# CITY OF ALBUQUERQUE

December 15, 2021

**Re: Burger King-Juan Tabo  
880 Juan Tabo NE  
Traffic Circulation Layout  
Architect's Stamp 11-23-2020 (K22-D035B)**

### DO NOT ENTER SIGN

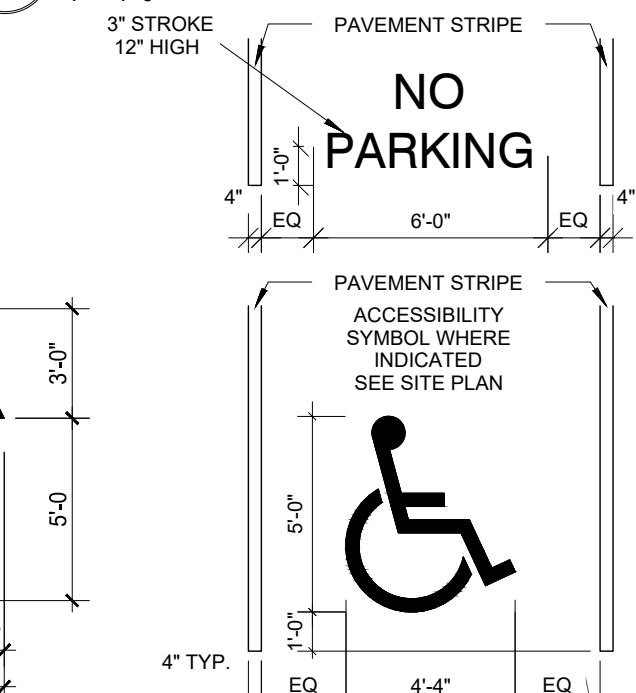
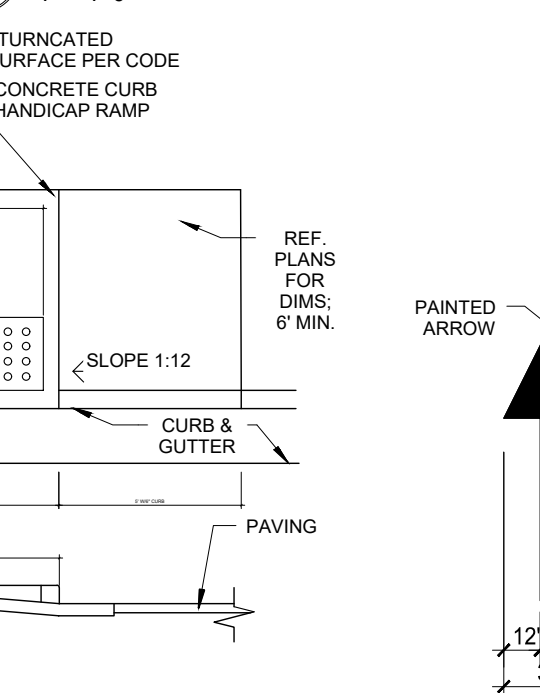
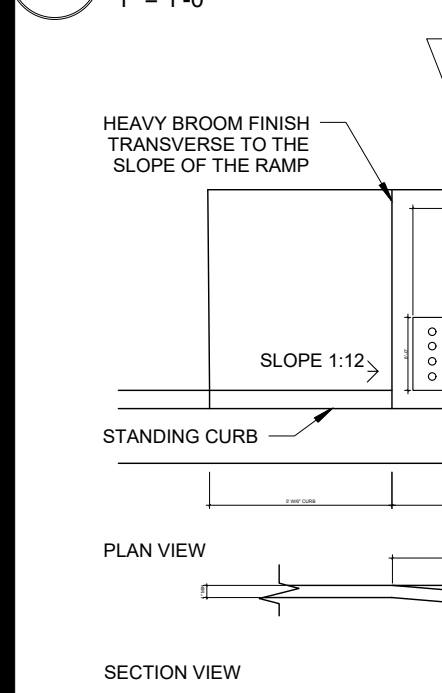
20. All one-way drives shall have "One Way" and "Do Not Enter" signage and **pavement markings**. Please show detail and location of posted signs and striping. Keyed Note 18 needs to apply to both sides drive thru exit.

### TRAFFIC CIRCULATION LAYOUT

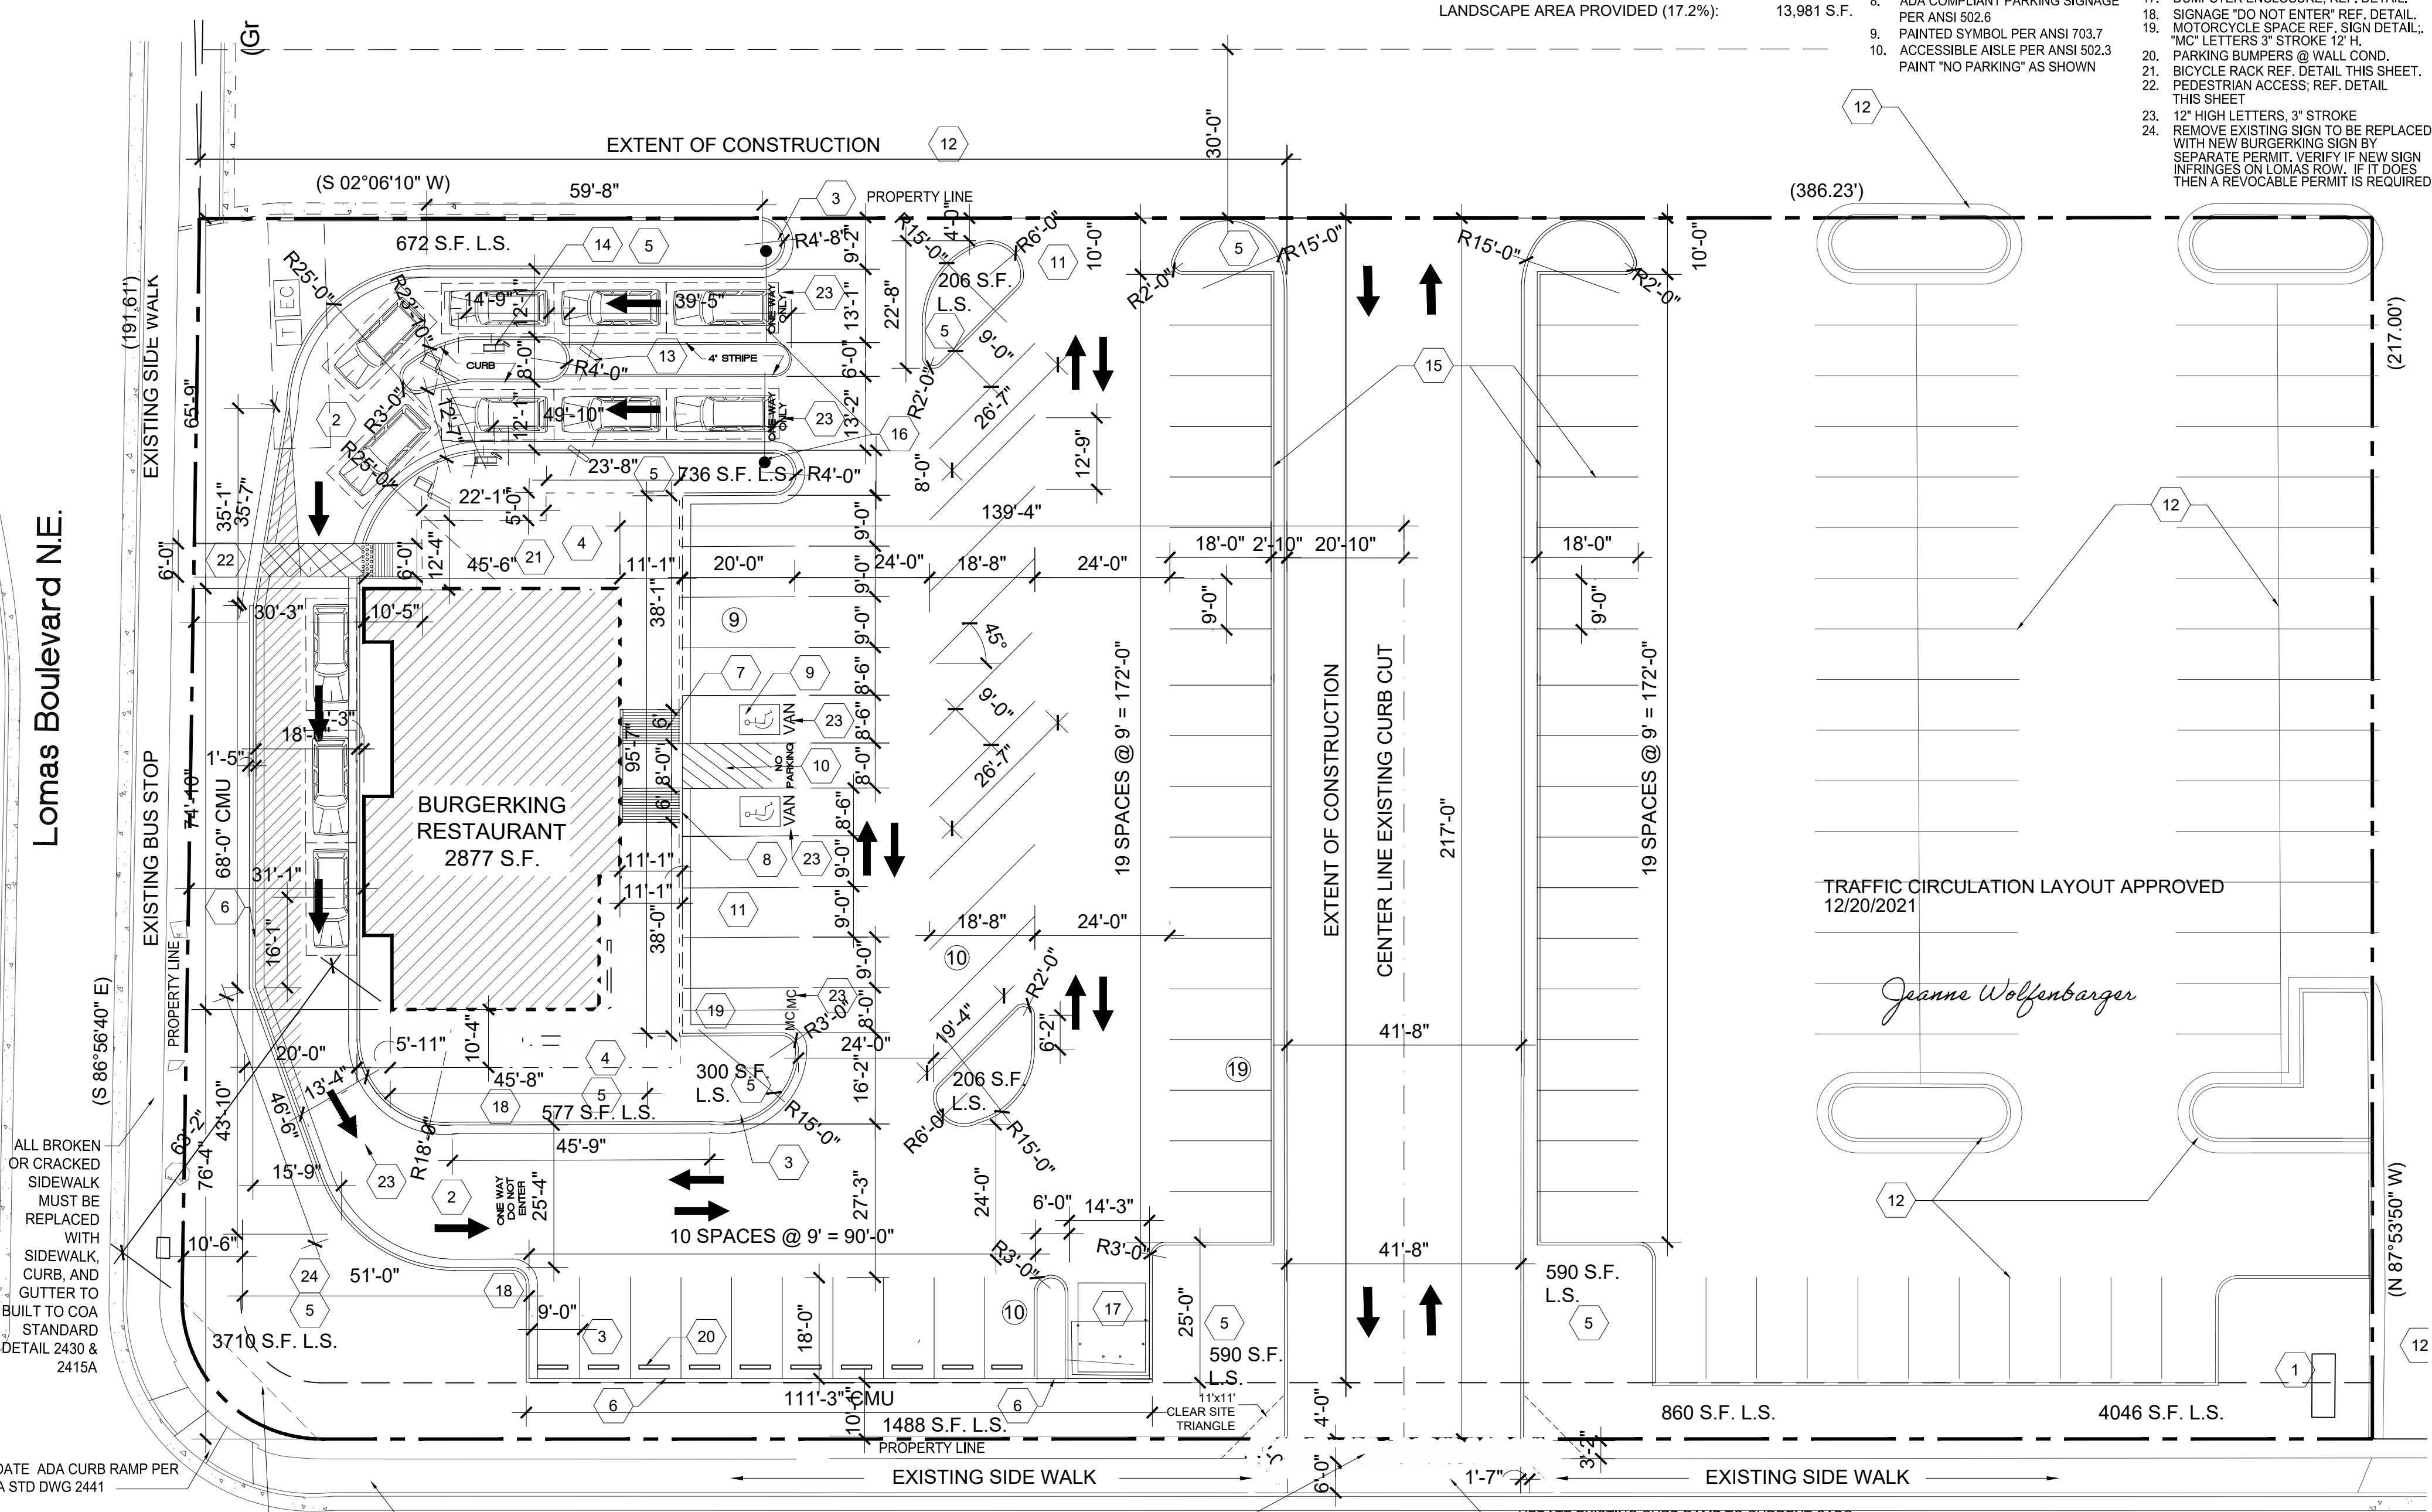
1. An overall plan will need to be provided demonstrating work limits as well pavement limit. Label all proposed parking lot infrastructure (keyed notes) and any details needed for construction.

2. **Property line:** You shown property line text between two lines. So, which of the lines is the property line? Please provide a line type for this.

3. **Juan Tabo (classified as an Arterial):**
  - A curb return is usually required off an Arterial per DPM requirements. Please justify utilizing the existing drivepad entrance instead of a curb return entrance.

- The minimum Throat length off an Arterial (Juan Tabo) for Commercial Development is between 100-150 feet. Please adjust your entrance throat depth on the main drive aisle to these required length prior. See DPM Chapter 23, Table 7.4.81 "Minimum Throat Length" (page 7-144).

4. **Lomas (classified as an Arterial):**
  - Verify the monument signage is not encroaching onto Lomas ROW. If encroaching then an Revocable permit will need to be provided.

- The existing monument sign ( AA Buffet Grill & Sushi) verbiage is in conflict with Burger Kings logo. Please address.
  - Existing drive entrance (west of the proposed development: You will need to provide the existing parking lot, drive aisle (layout) to show that the geometric circulation has not compromised drive aisle widths and traffic flow.

5. Verify, corner of Lomas/Juan Tabo, the existing ramp is current/update ADA ramp design ( ADA compliant) and/or reference details.

6. All proposed infrastructure will need details which include on site ramps, curbing etc... (includes keyed note references).
7. The ADA parking stall ramp appears to be a tripping hazard! Do you need to provide railing ramp to service the lateral paths?
8. **Keyed Note 12 & 15:** What do you mean? You are showing on plans so please hatch out what is not part of TCL project.
9. **The minimum parking stall dimensions are (ADA stall width=8.5'):**

10. You show the detail s/words "**COMPACT**" but not shown on parking lot. Why?

11. Proposed ADA parking stall and standard stall fronting the building will need parking bumper so 6 ft ADA pathway will not not reduced/compromised of its 6 ft width.

12. The ADA access aisles shall have the words "**NO PARKING**" in capital letters, each of which shall be at least one foot high and at least two inches wide, placed at the rear of the parking space so as to be close to where an adjacent vehicle's rear tire would be placed. (66-1-4.1.B NMSA 1978) . **Pavement marking details will need to be provide for this pavement text.**

- Shall be designated by its own conspicuously posted upright sign, either free-standing or wall mounted per the zoning code. Details needed.
- Label pavement MC.
- No parking stalls shown on site plan?

- Provide angle to determine appropriate stall length.

15. All internal radii's will need to be 15'R. Some aren't. Adjust.

16. Per the DPM, a 6 ft. wide ADA accessible pedestrian pathway is required from the public sidewalk to the building entrances. Please clearly show this pathway and provide details. Verify a clear width of **unobstructed ADA pathway** is provided from public sidewalk to building entrance.

17. Per DPM, a **6 ft. wide ADA accessible pedestrian pathway** is required from the ADA parking stall access aisles to the building entrances. Please clearly show this pathway and provide details. The is a cap between public sidewalk and private property.

18. **Fire Department:** An approval Fire 1 plan needs to be provided.
19. **Keyed 2:** It is not apparent what type of pavement surface is being proposed. A hard driving surface will be required as part of this proposed project for parking area and drive aisles. **Provide detail.**

21. **Drive Thru Lanes:**
  - Provide striping details for all proposed.
  - Widths will need to be shown thru all transitions. Some are not shown.
  - Minimum widths need to be 12 ft.

22. You have a conflict with several parkings stalls and Drive Thru Exist lane. Please adjust to avoid these vehicle conflicts. Vehicle backing versus drive thru movement out of lane/aisle.
